TRAFFIC IMPACT STUDY

12057 Highway 24 Multifamily Rezone
El Paso County, Colorado
PCD Number P264

January 2026
Revised April 2026

Figure 3
BACKGROUND TRAFFIC - YEAR 2028
Volumes & Intersection Geometry
AM / PM Peak Traffic Hour
(ADT) : Average Daily Traffic

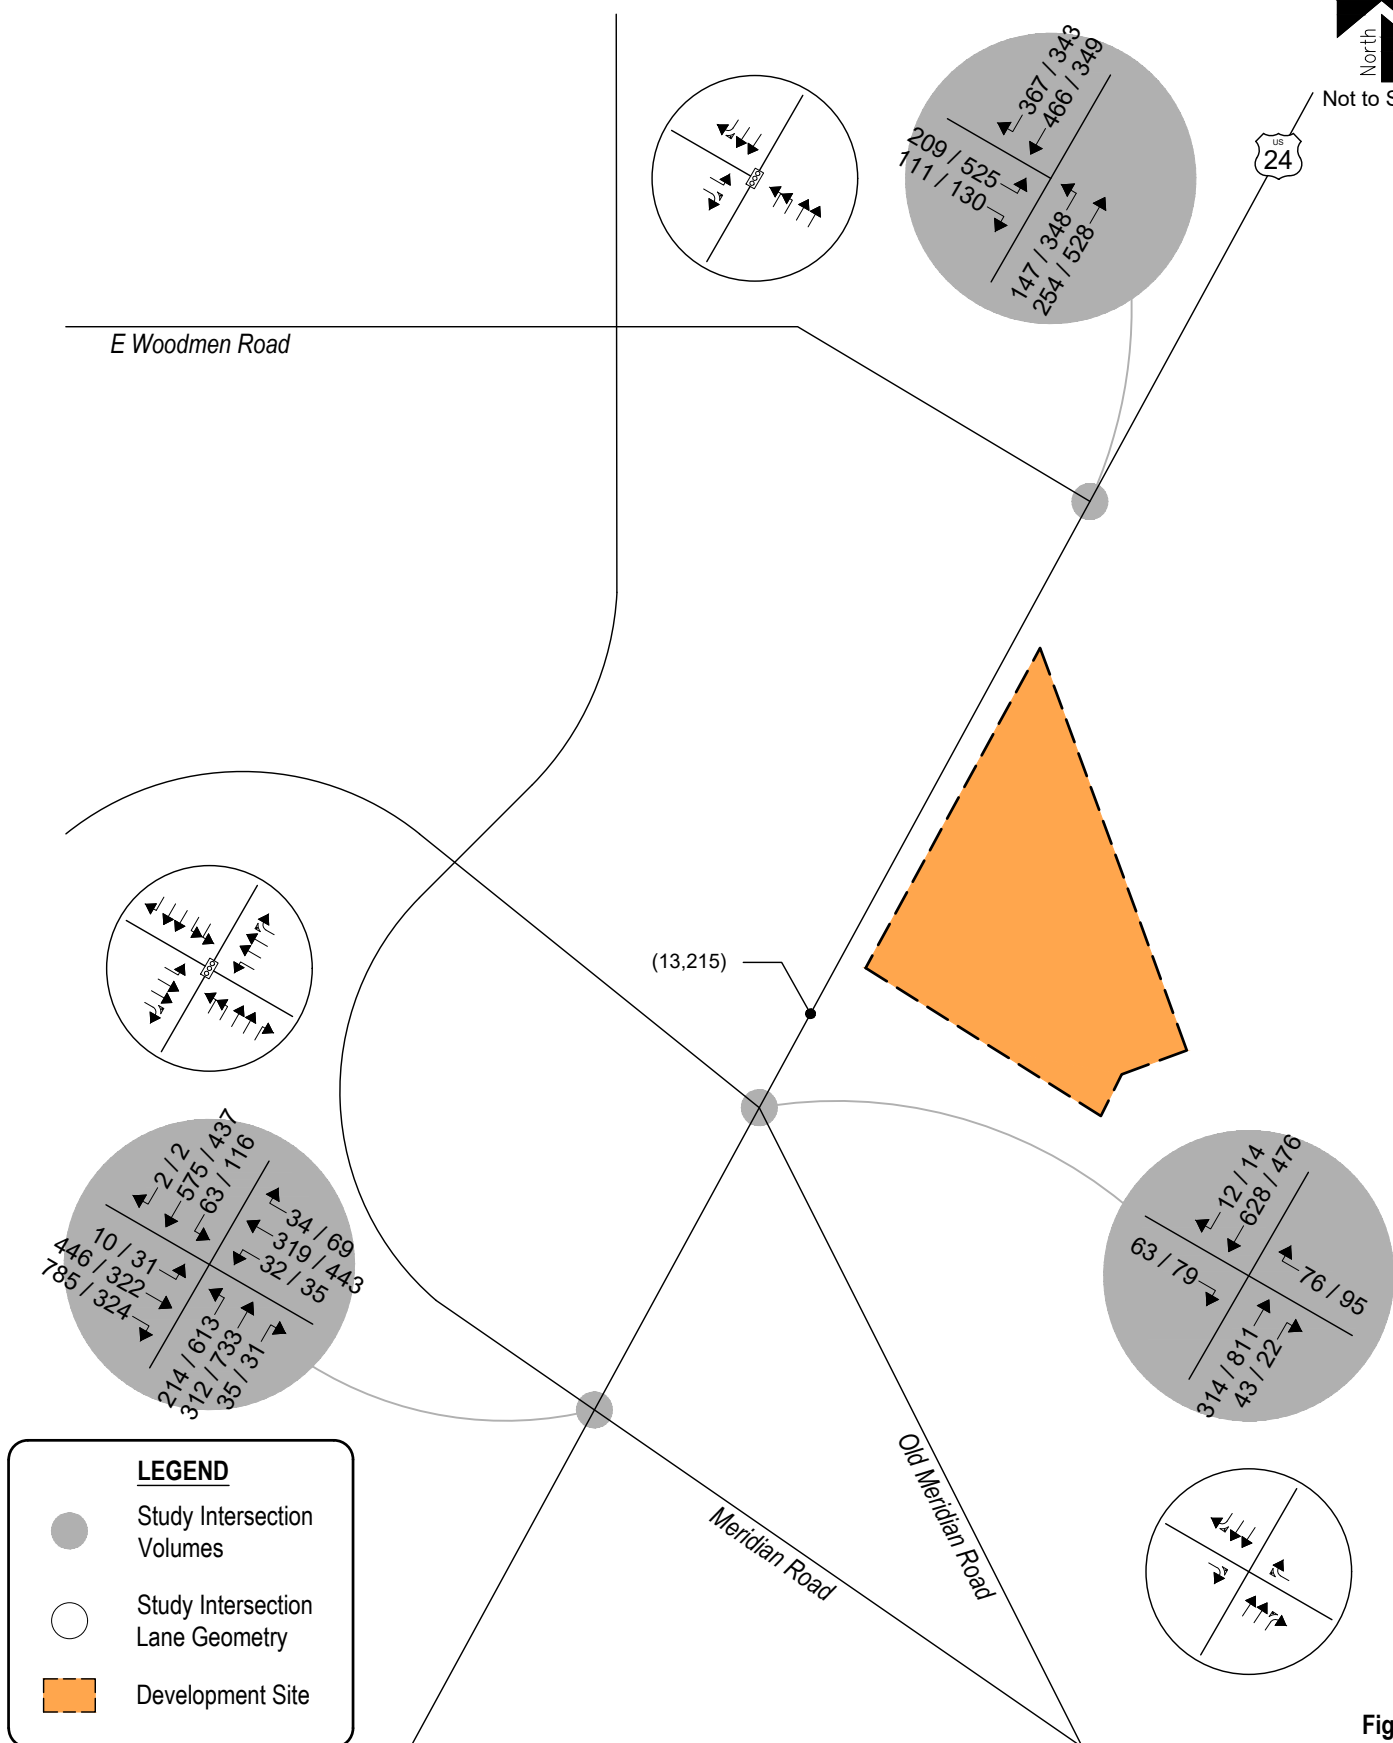
The Falcon Field development that constructs the 4th leg of the intersection has a build out year of 2028 per the TIS which should be included in this background.
